Fwd: 415 Cumberland Ave

Rob and I looked over this proposal. We're OK with this change pending the following conditions:

ELEVATIONS

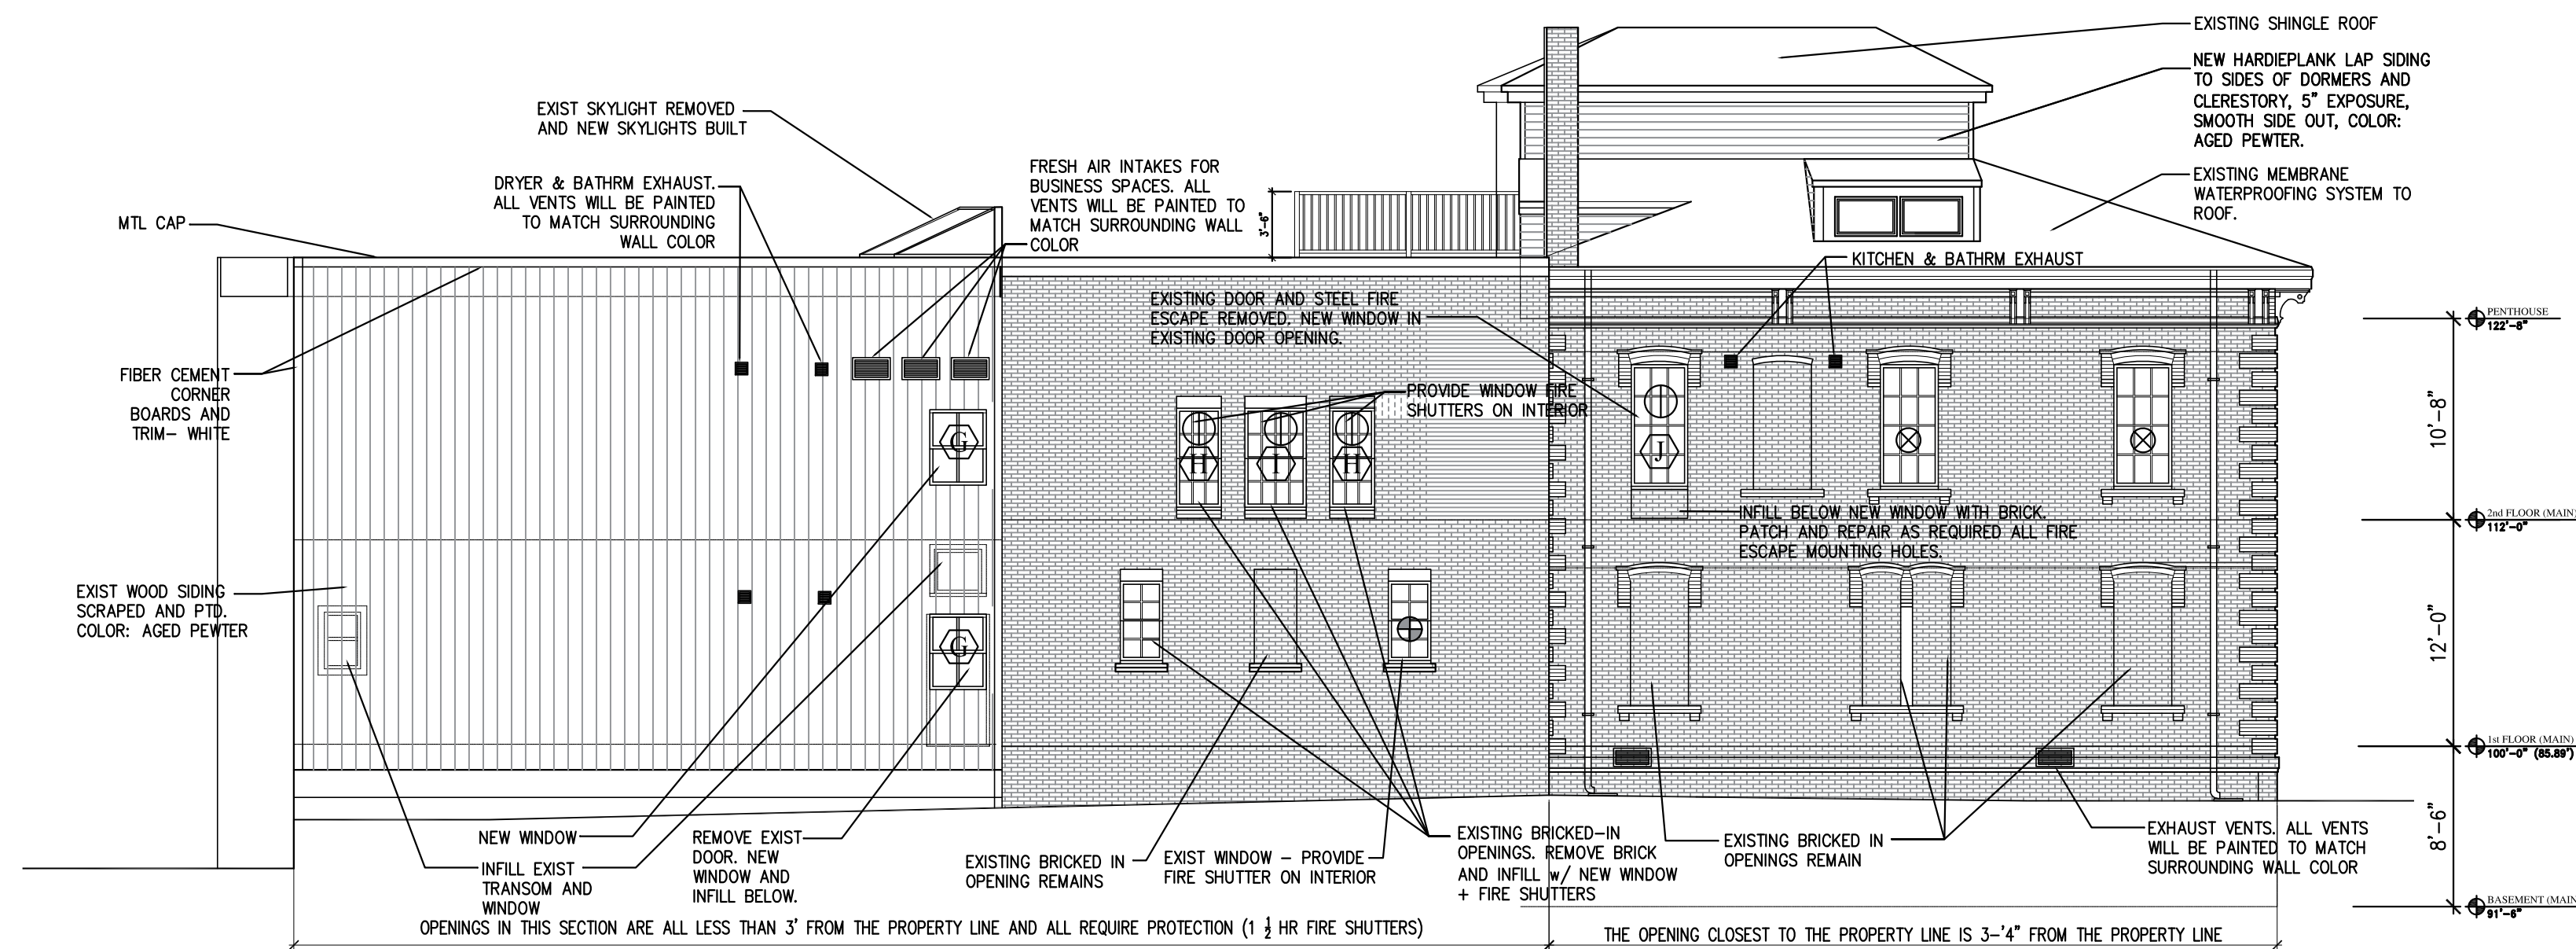
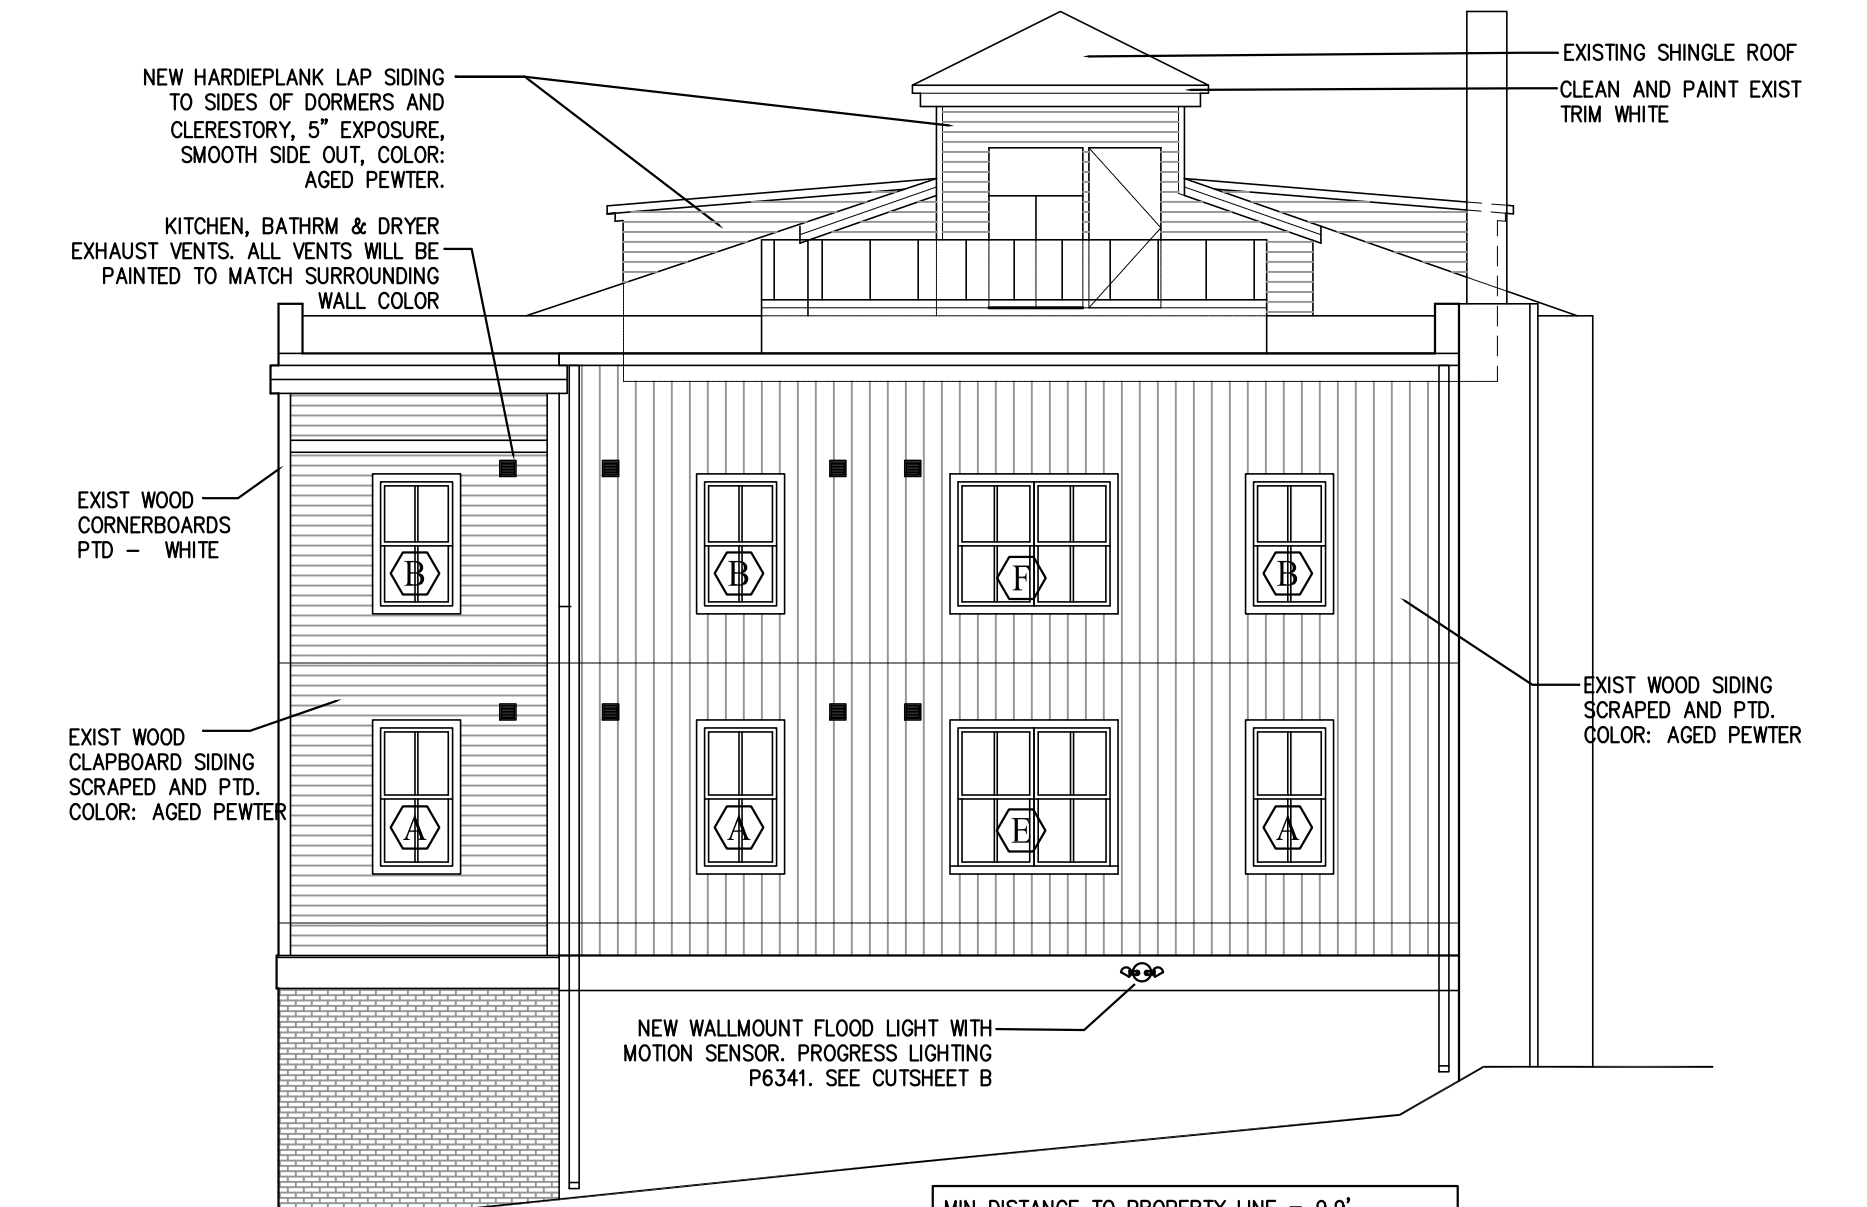
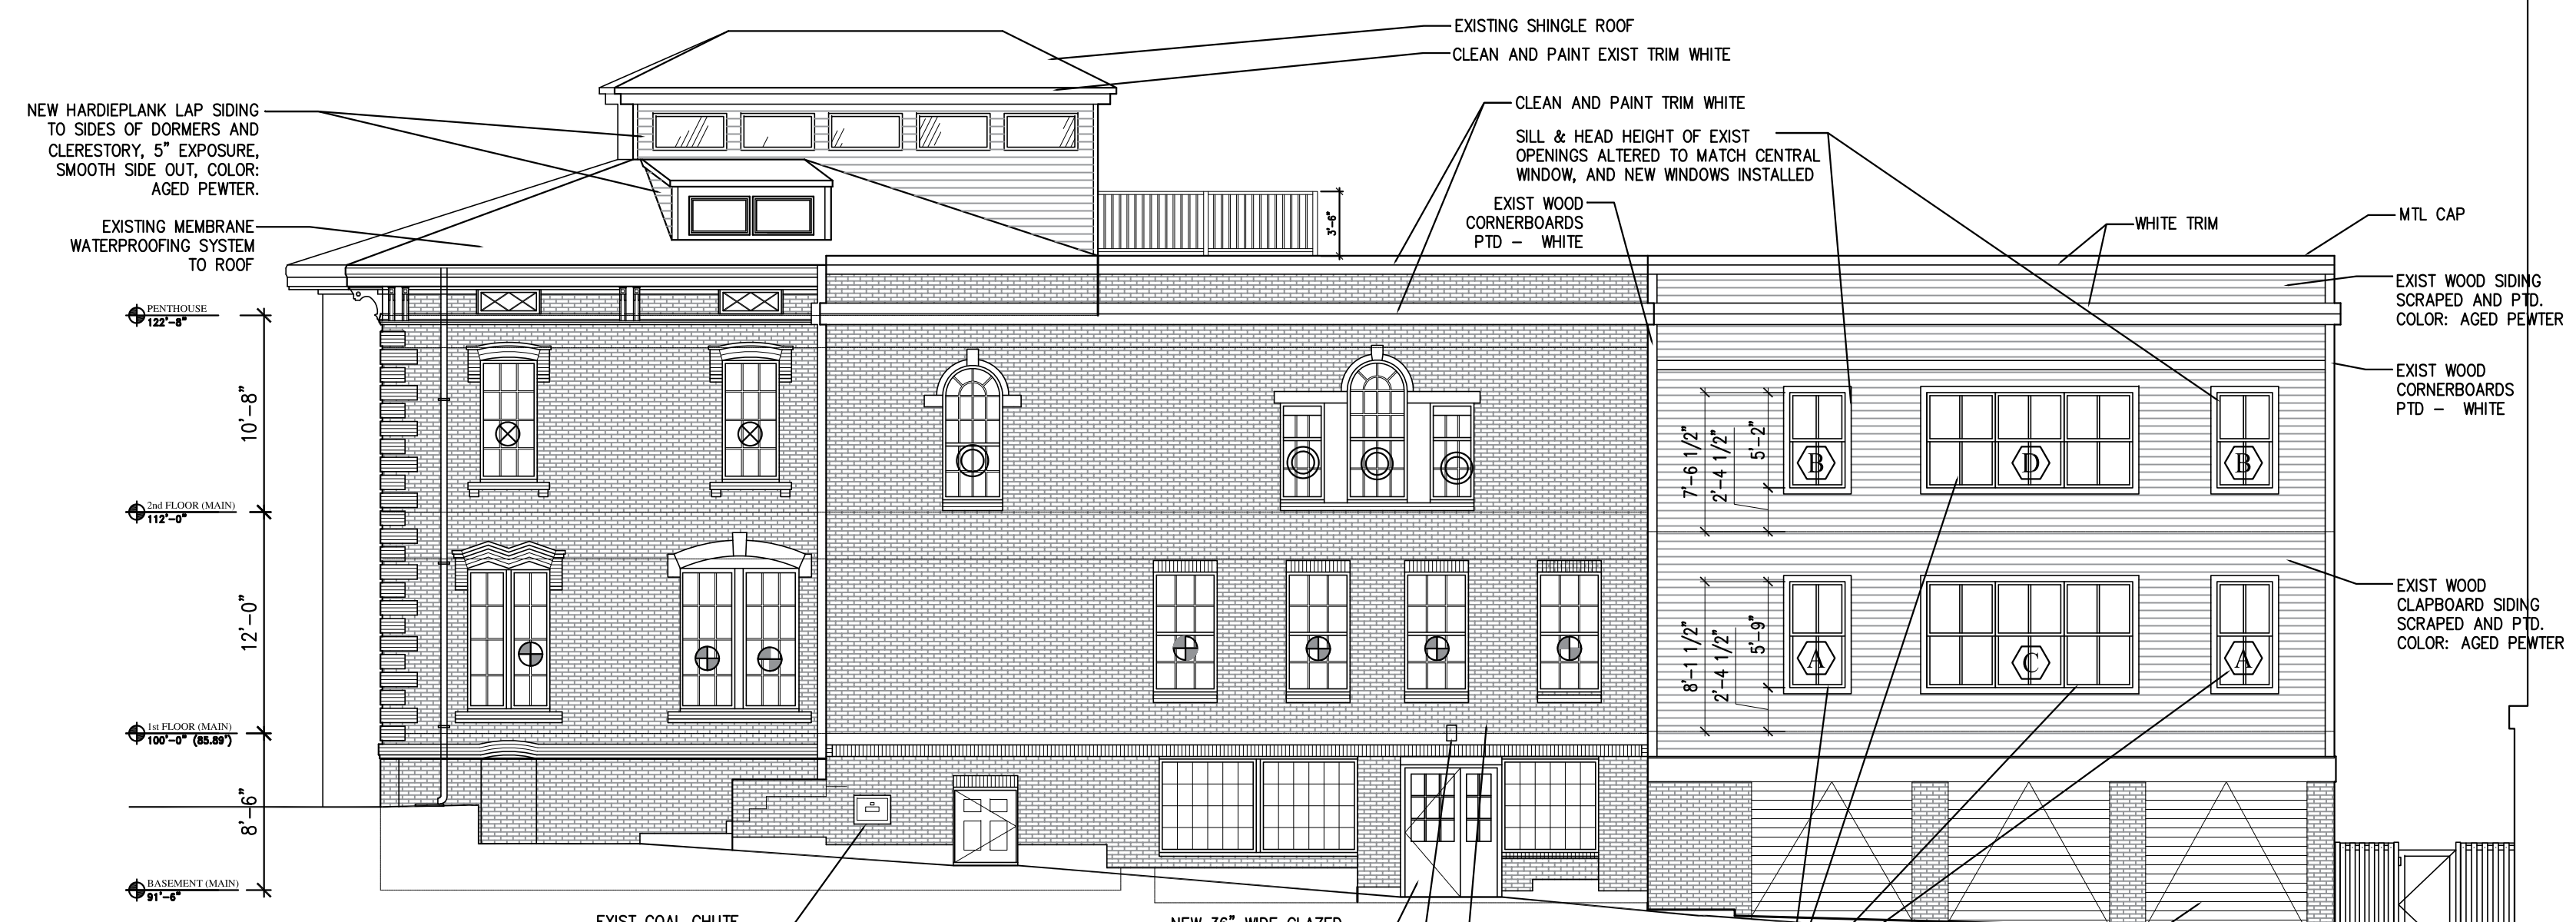
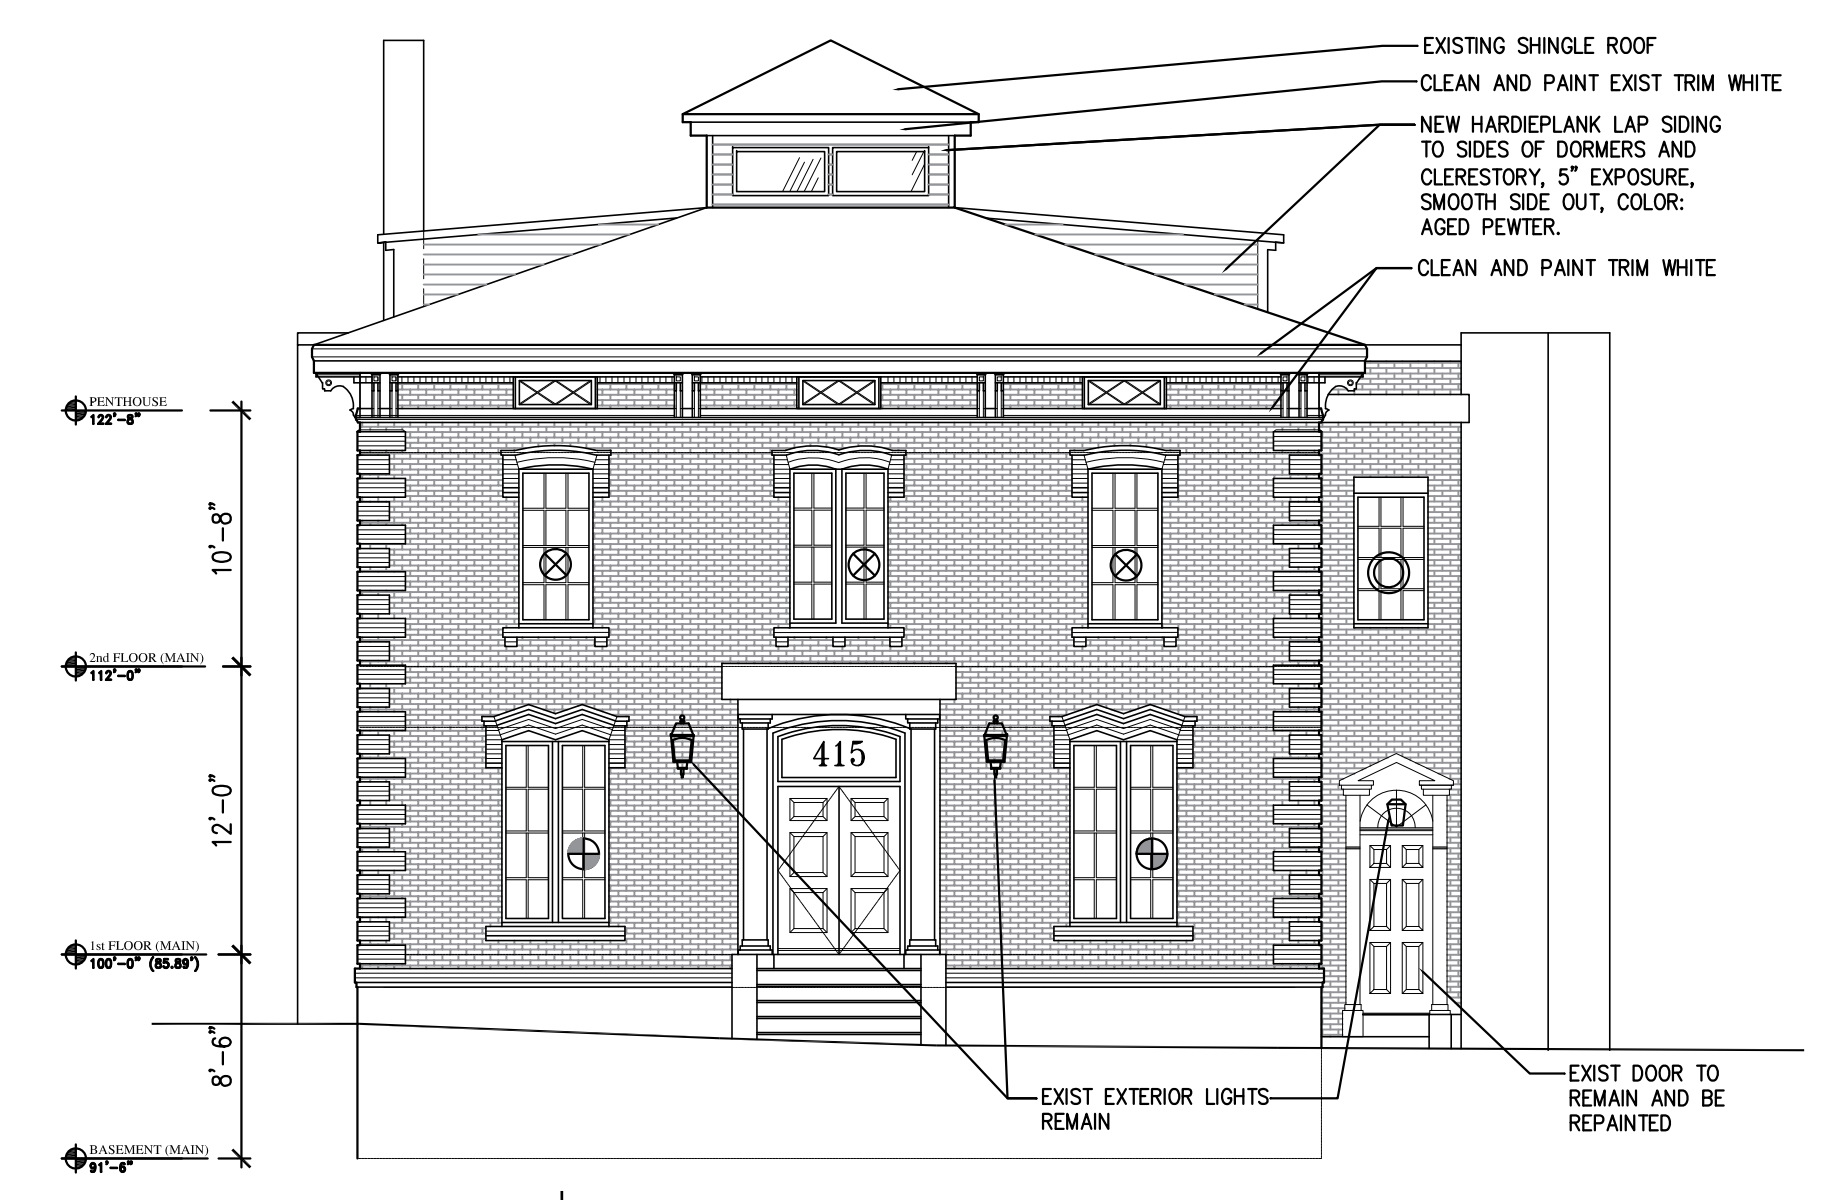
- 1) New sills will match the existing sills
- 2) Historic preservation staff shall review brick and mortar styles / consistency / color prior to installation. Please reuse existing brick from the project site if appropriate / possible.
- 3) *Window configuration shall be **six over six**.*
- 4) Windows shall be aluminum clad wood double hung windows matching the previously-approved windows for the brick section of the building.

1. Yes, we will match new sills with old.
2. We do not intend to reinstall any brick, unless required around the sills to match. We will send photos of the existing conditions with a clear description of the approach to alterations with any necessary pictures prior to installation for your and Deb's approval.

3. Window configuration will be 6 over 6.
4. Windows will be aluminum clad, made to match the double hung windows, though in order to achieve proper clearances for egress they must operate as casement style windows. I will send details to you for your and Deb's review as soon as I have them. As you know, we intend to use two types of windows on this project H3 and historic windows, all aluminum clad by Sierra Pacific, in line with our previous submissions. In my last correspondence with you and Deb on this topic, I shared the attached which shows these specific widows as the H3 versions. I intend to continue with this approach, unless this is no longer acceptable. Please let me know as soon as possible as the other windows on this elevation have been ordered.
